City of Portland, Maine - Building or Use Permit

Permit No: 06-1001	Date Applied For: 07/07/2006	CBL: 111 A010001
-----------------------	---------------------------------	---------------------

Location of Construction: 425 FOREST AVE	Owner Name: FLETCHER WENDALL M JR	Owner Address: 48 REVERE ST	Phone:
Business Name:	Contractor Name: Sign Concepts	Contractor Address: 9 Storm Dr Windham	Phone (207) 899-6454
Lessee/Buyer's Name	Phone:	Permit Type: Signs - Permanent

Proposed USE: Stavros Pizzeria & Deli- new signage 63 Sq Ft (freestanding sign) & awning with signage	Proposed Project Description: new signage 63 Sq Ft (freestanding) & awning with signage.
---	--

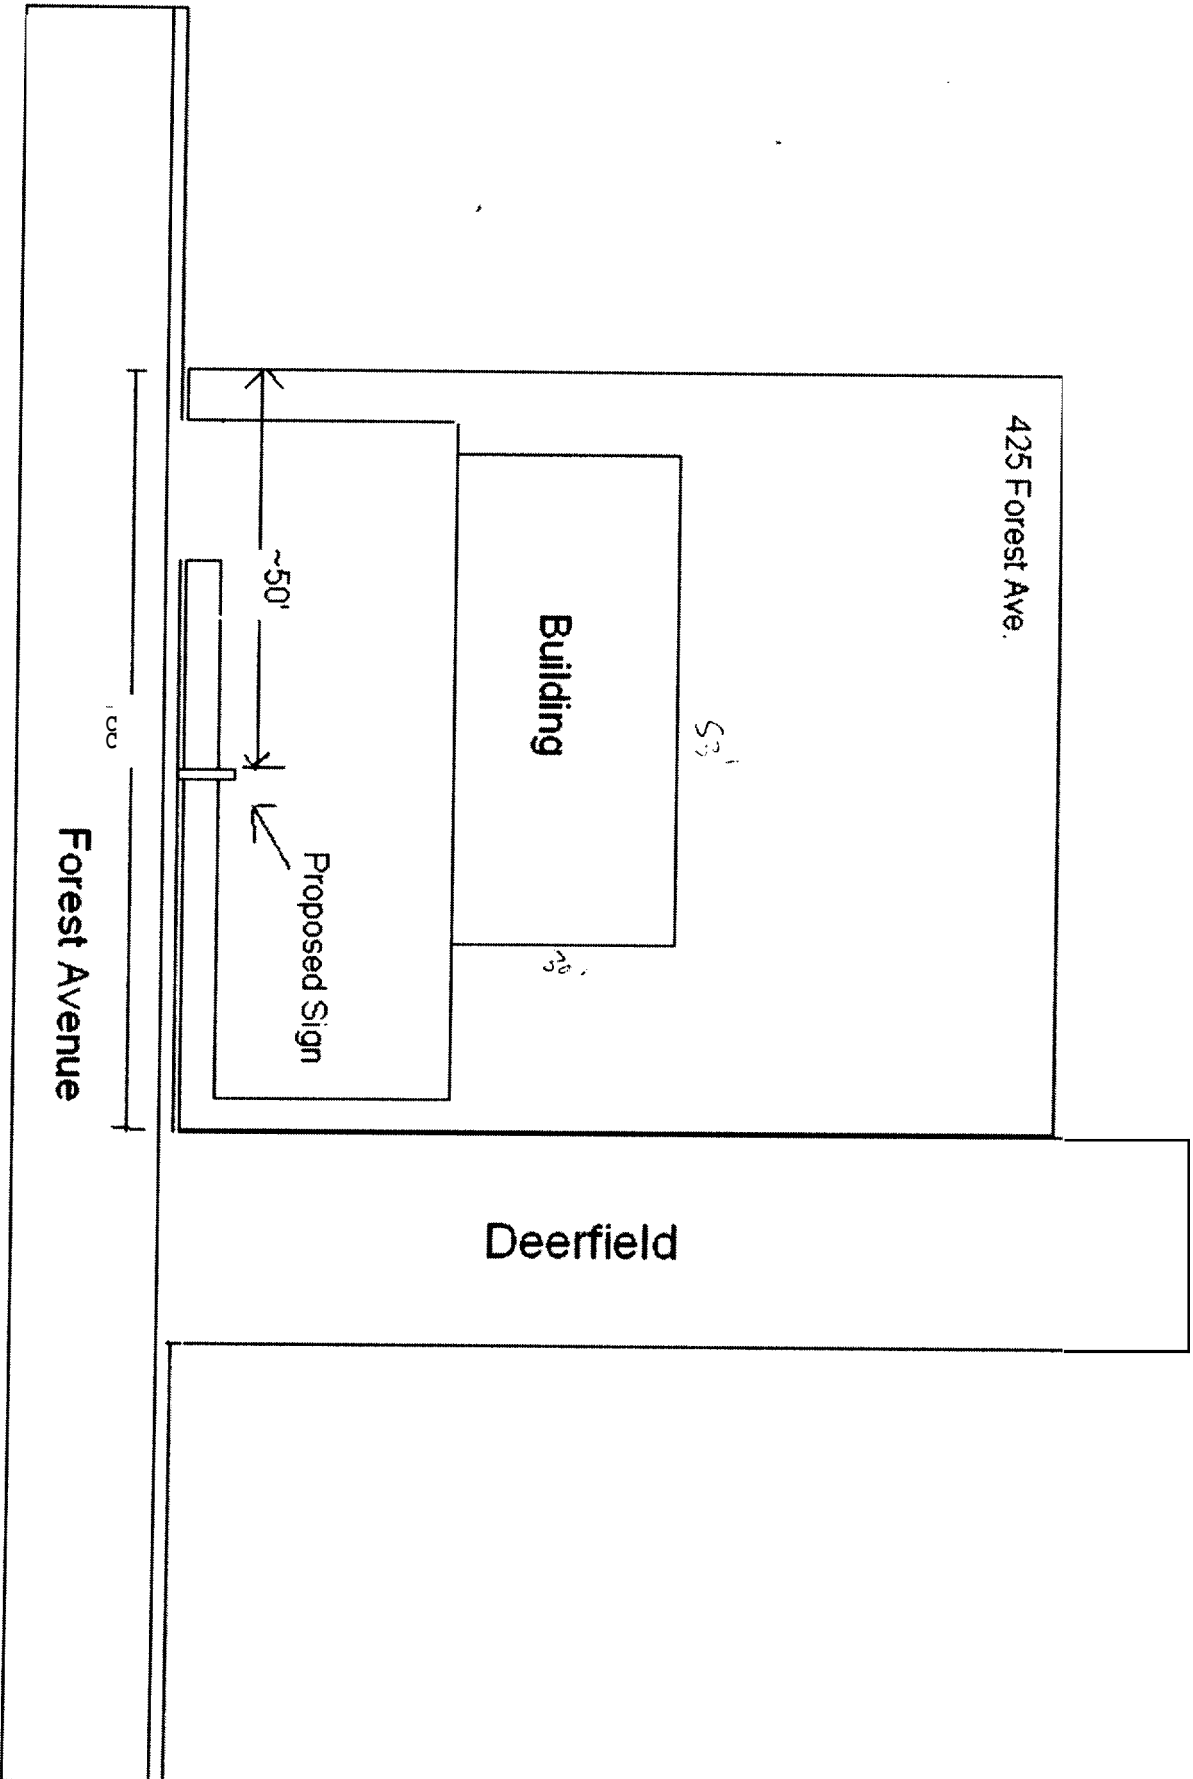
7/13/2006-amachado: Left message with Andrew at Sign Concepts. Need Scalable sign plan to show exactly how the actual face is 63" and we need plot plan to indicate that the free standing sign is a minimum of 5' from the property line.

8/2/2006-amachado: ~~Left~~ message with Andrew from Sign Concepts. He called on 8/1/02 to say that they wanted to use the pole from the previous business, but it is not five feet from the property line. I told him that if only the pole is left and not the frame then they have lost the nonconforming use of the sign location and that the new sign must be located at least five feet from the front property line.

8/7/2006-amachado: Owner & tenant brought in picture which shows that the old sign and frame still exist so the location for the new sign is legally nonconforming and can be less than 5' from the property line.
